From: Laura Mepham
Sent: 04 March 2025 14:33
To: Nick Hirst <Nick.Hirst@kirklees.gov.uk>
Subject: RE: S73s at Crossley (2024/92774, 2024/92775, 2024/92776)

The plans attached to this email relate to Parcel 4 – Ref - 2024/92774 & 2024/92775.

**DRAWING NUMBER:**  
23-5666-5056A

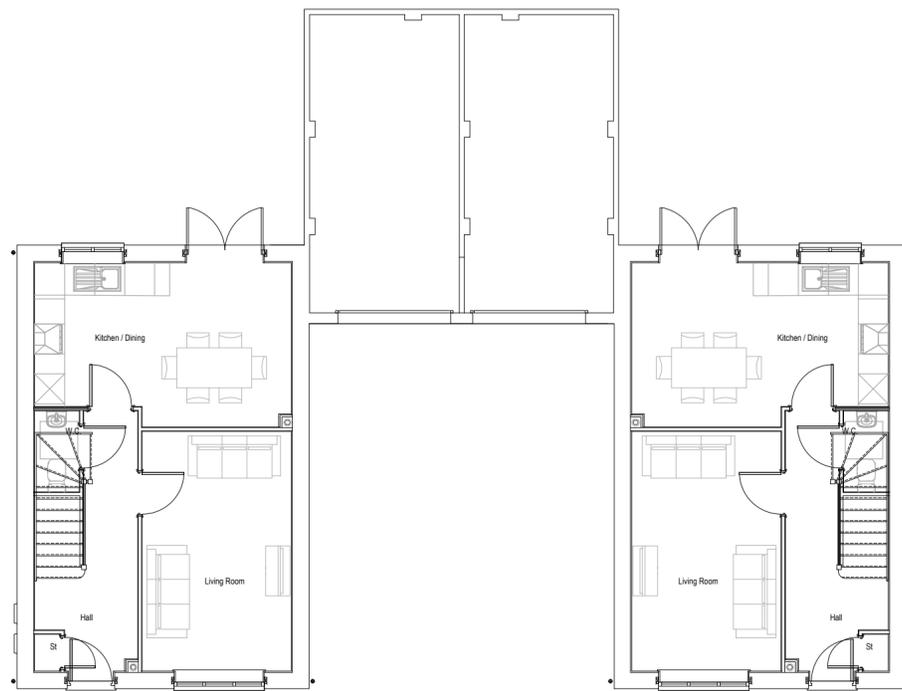
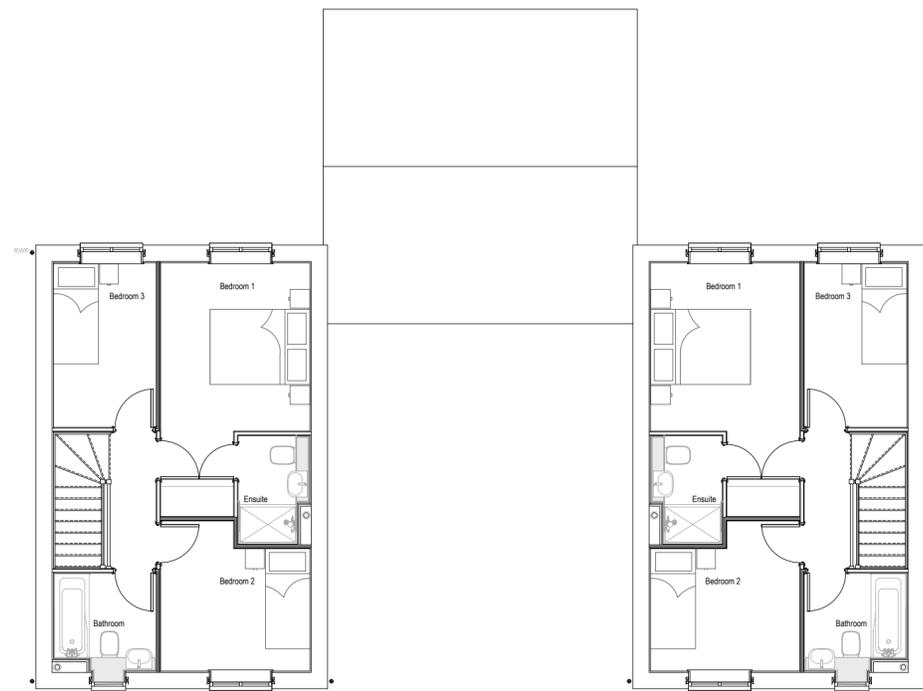
Crest			
Housetype	Beds	m2	NDSS
2B.CR2	2B/3P	71	70
TC2+	2B/3P	77	70
TF previously approved type	3B/4P	82	84
3B.L1	3B/4P	82	84
3B.H1	3B/4P	80	84
3B.R1	3B/4P	86	84
3B.CH2	3B/5P	93	93
TG	4B/6P	109	115
TP	4B/6P	111	106
4B.F2	4B/5P	105	103
4B.K1	4B/6P	114	106
4B.H2	4B/7P	120	115
4B.D1	4B/8P	128	124

DRAWING NUMBER:
23-5666-5053

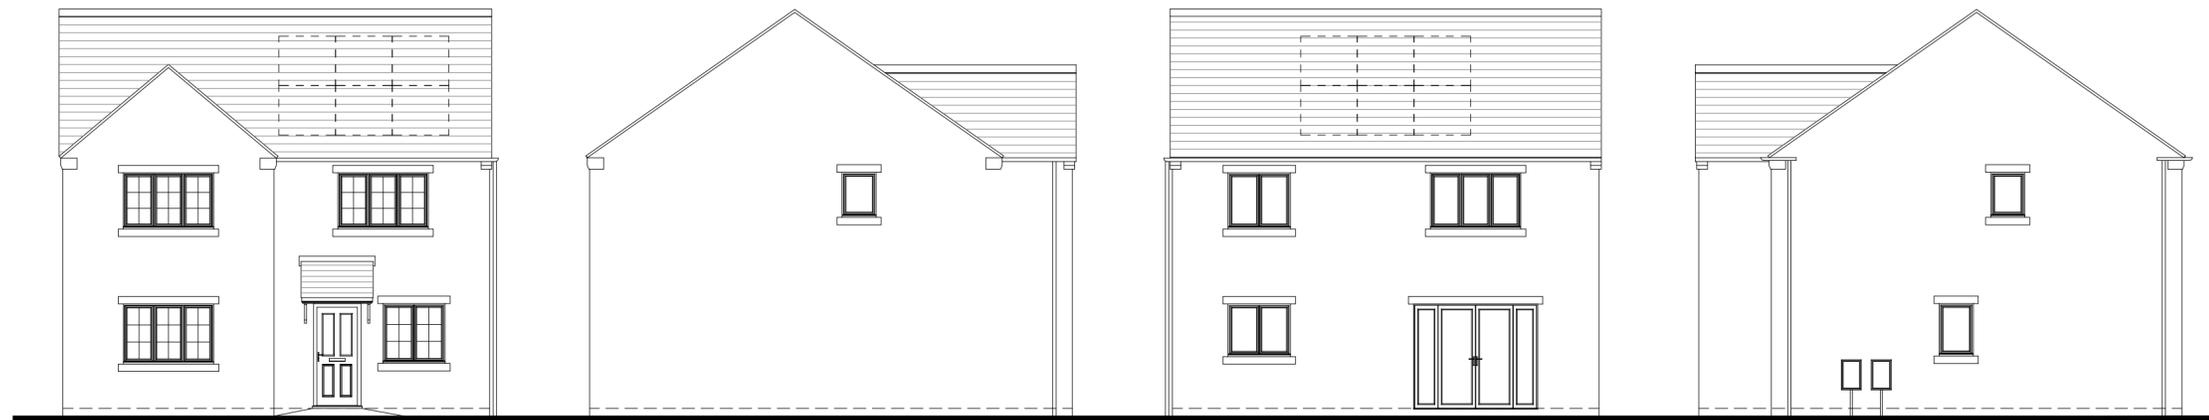
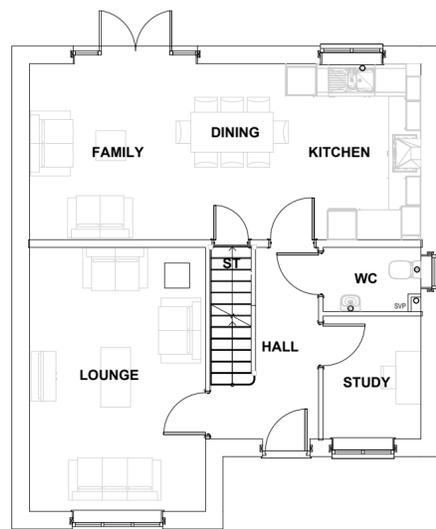
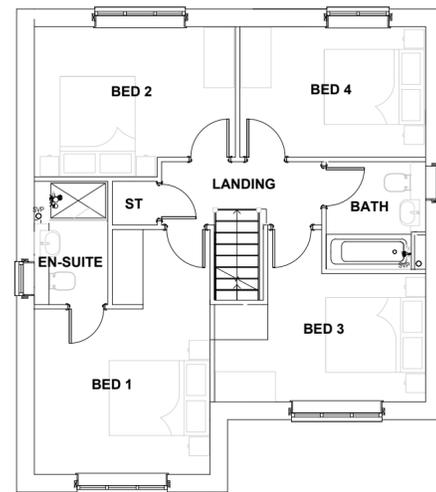
- All flat roof dormers have been replaced with a pitched dormer.
- Heads and cills have been added to front and rear elevations
- Rendered units on the site's frontages swapped to the approved (art) stone
- Meter boxes relocated to side elevations where possible.
- Parcel 4 – Plots D1 and D2 as submitted were a pair of semi-detached, as requested this has been amended to reflect the consented layout with a Type P proposed, which is art stone. Plots D44-52 have been revised to maintain the overall plot numbers on this Parcel at 52.
